**WELWYN HATFIELD BOROUGH COUNCIL
ASSISTANT DIRECTOR (PLANNING)**

DELEGATED APPLICATION

Application No: 6/2023/2036/HOUSE
Location: Wing 2 Warren Wood Kentish Lane Hatfield AL9 6JQ
Proposal: Erection of front portico with alterations to fenestration, detached granny annexe, detached garage and hard and soft landscaping works following the demolition of existing front extension and outbuildings
Officer: Ms Elizabeth Mugova

Recommendation: Refused

NO.	REVISION	DATE	PROJECT	TITLE
			WINGS 2, WARREN WOOD PARK, BROCKMANS PARK	EXISTING AND PROPOSED SITE PLANS
			CLIENT PRIVATE CLIENT	DRAWING STATUS PLANNING
			SCALE 1:500	DRAWING REF. 002
			SHEET A1	REV. -
			DATE JUNE 23

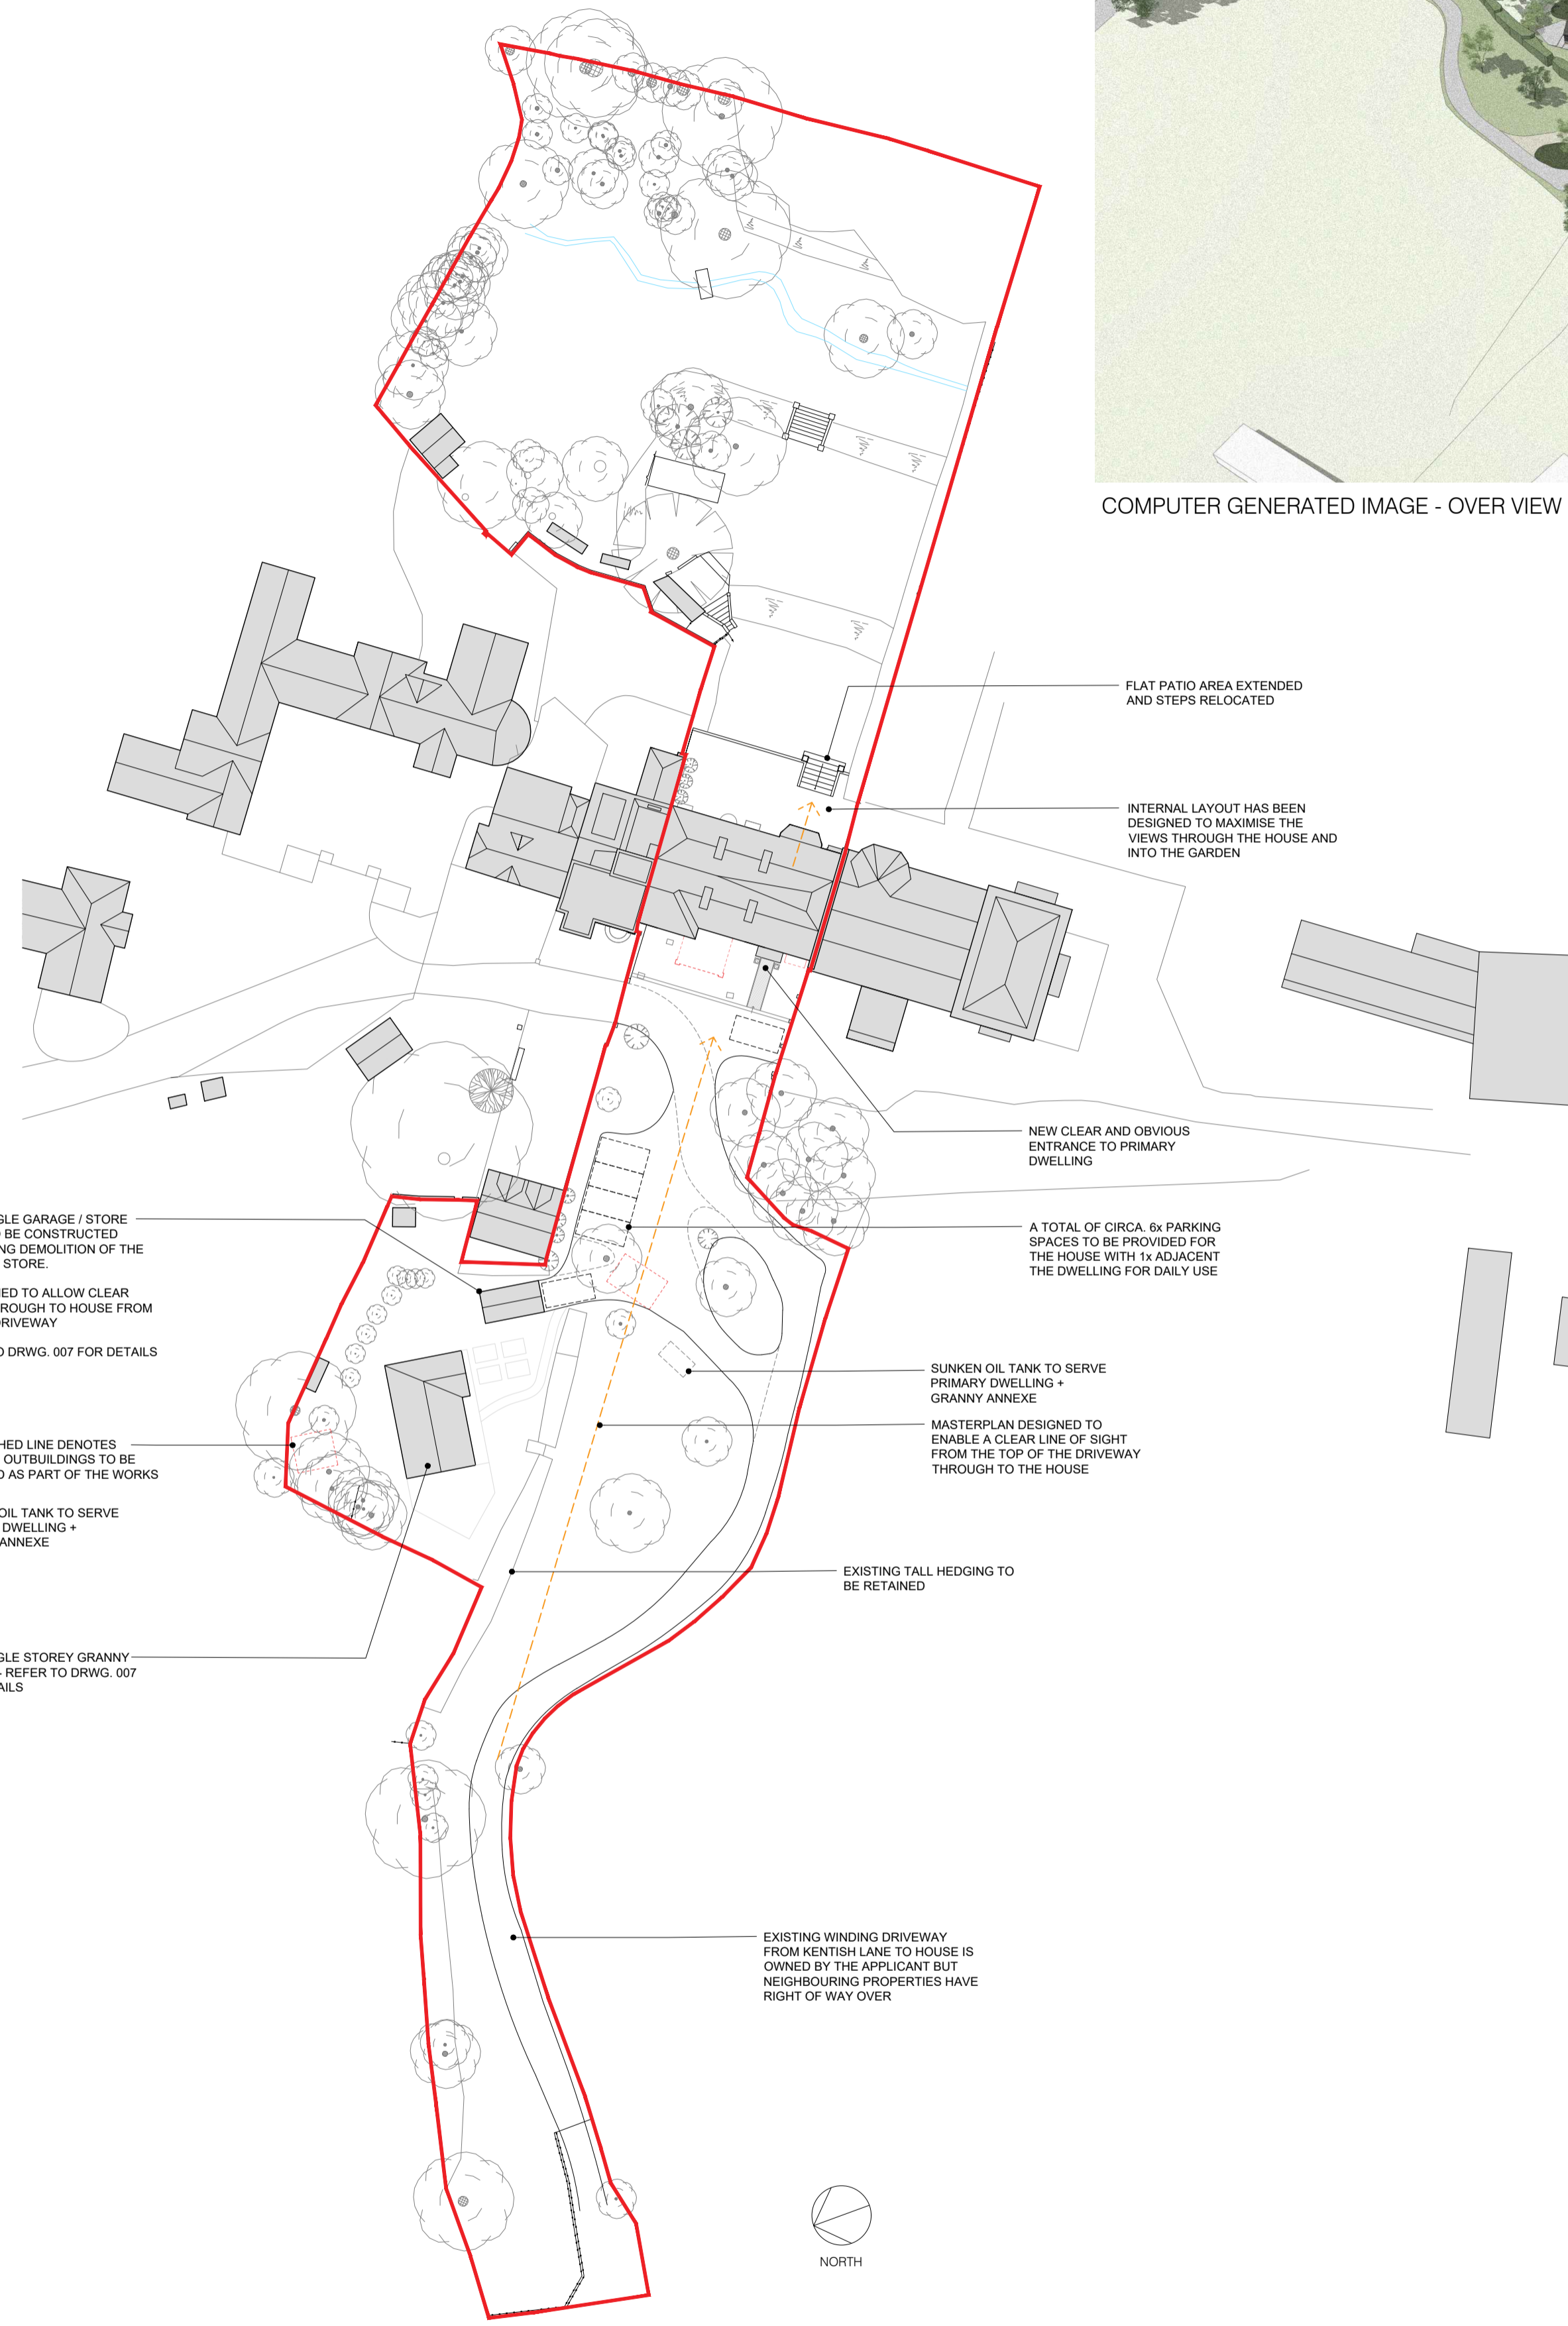
Whilst it is acknowledged that the granny annexe, and its garage, would replace some existing built form. For reasons discussed above, the new buildings would be materially greater in size than the existing buildings they would replace. In addition, the proposals would result in the material change of use of a substantial amount of land through the land directly associated with the granny annexe but also the wider area of land discussed above. As a result of these factors, it is considered that these elements of the proposed development by virtue of its residential design, appearance and layout would introduce an urban form of development into this part of the countryside, with the resultant loss of the site's open and undeveloped character. It is therefore considered, for the reasons discussed above, that the proposed development would fail to safeguard the countryside from encroachment, in clear conflict with purpose (c) of paragraph 143 of the NPPF.

The proposed granny annexe and the garage would be physically detached from the host property (approx. 40m away from the front elevation) and would be sited within an area enclosed by an existing hedge. Its scale, layout and design of these buildings mean that they would have the appearance of modest dwelling, with an associated garden and garage. In addition, for the reasons discussed already in this report the proposed annexe would not fall within the permitted residential use of the application dwelling and it is considered that it would be outside the residential curtilage of the dwelling within the site. Furthermore, although the annexe and host dwelling would share vehicular access route from Kentish Lane, it is unclear from the submitted details what else they would share as the proposed granny annexe would have its own garden, garage and all the facilities required for independent living. In addition, whilst they would share an access, due to the positioning of the granny annexe within the site, the sharing of this access would be more akin to that of an access shared by independent dwellings instead of a building with an ancillary use to the primary use of the site.

NO.	REVISION	DATE	PROJECT	TITLE
			WINGS 2, WARREN WOOD PARK, BROCKMANS PARK	PROPOSED PLANS
CLIENT			PRIVATE CLIENT	DRAWING STATUS
SCALE			1:100	PLANNING
SHEET			A1	DRAWING REF.
DATE			JUNE 23	REV.
			004

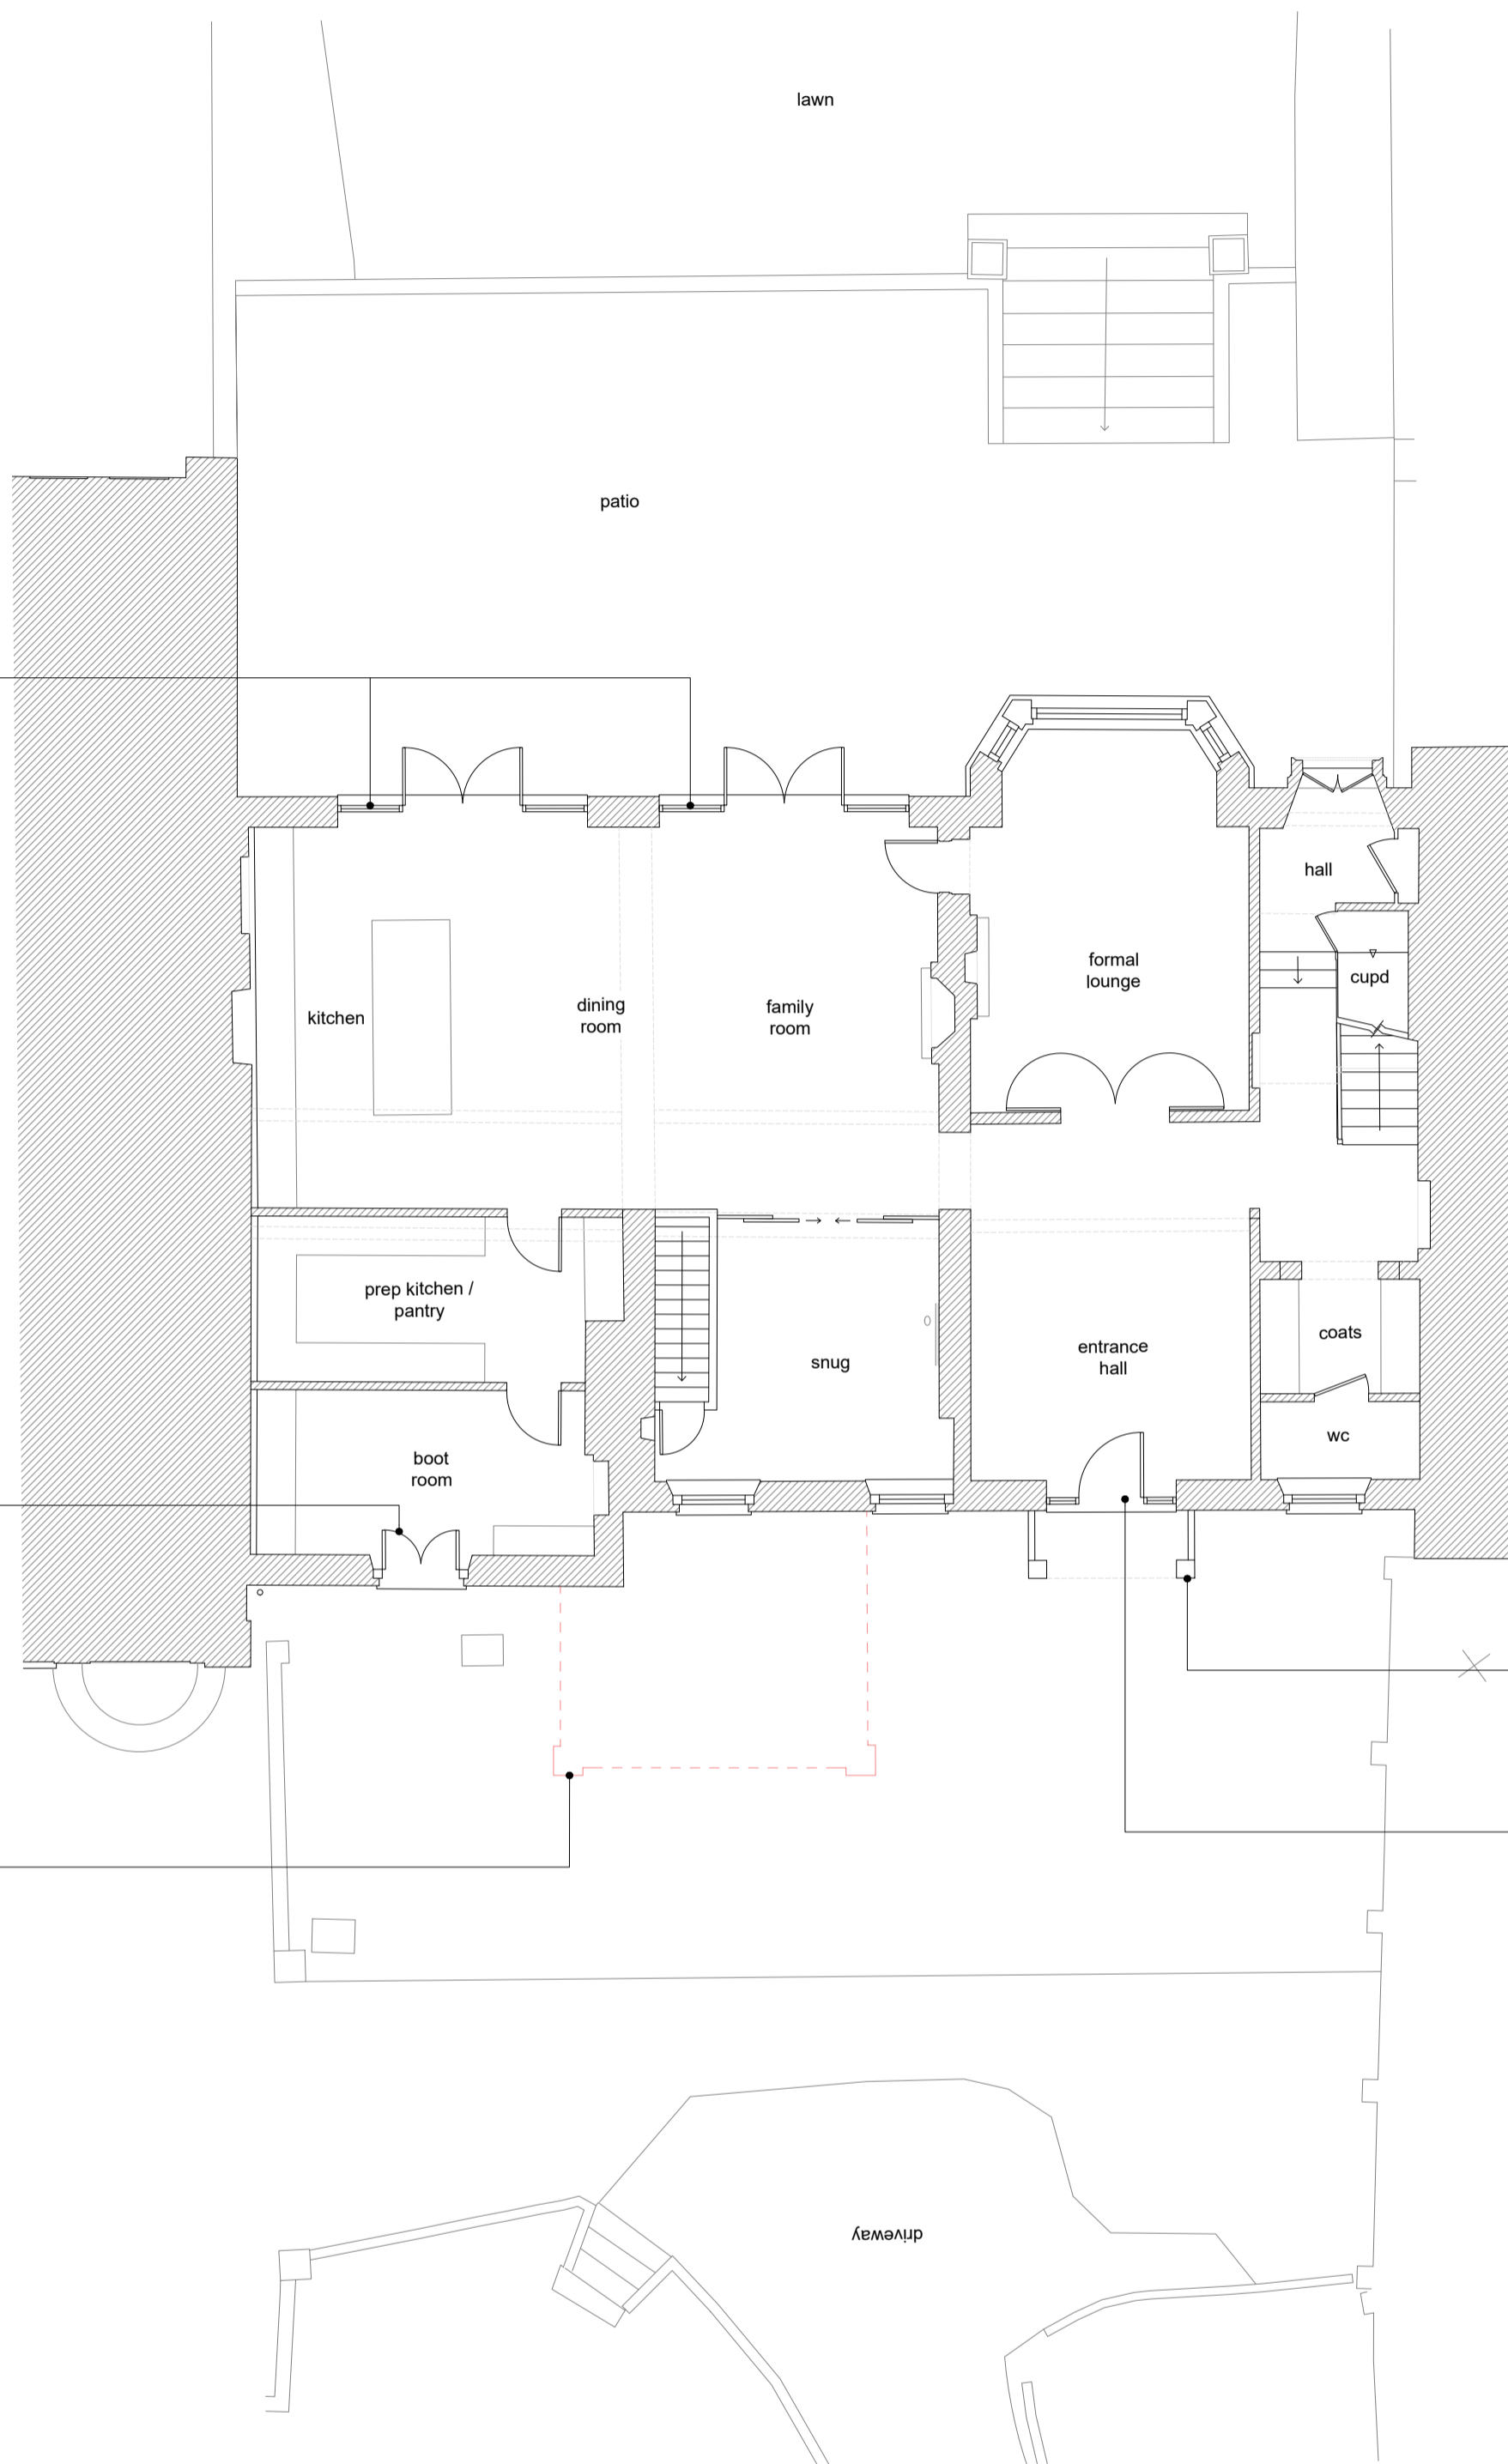
In terms of the proposed front portico and alterations to fenestration, the existing front extension which measures approximately 18m² would be replaced with a stone portico to provide cover to the front door. This element of the proposal would result in a significant reduction in volume and area and would constitute appropriate development within the Green Belt. Furthermore, the front portico and alterations to fenestration would not have a visual impact upon the openness of the Green Belt

Turning to the proposed front portico and fenestration, this element of the proposal would not detract from the character of the host dwelling. The proposed changes would result in the property appearing as a more cohesive piece of architecture, enhancing the immediate setting. The proposed external materials would fit in well with the surrounding properties and the rural setting. In the event of an approval external materials can be secured through a condition.
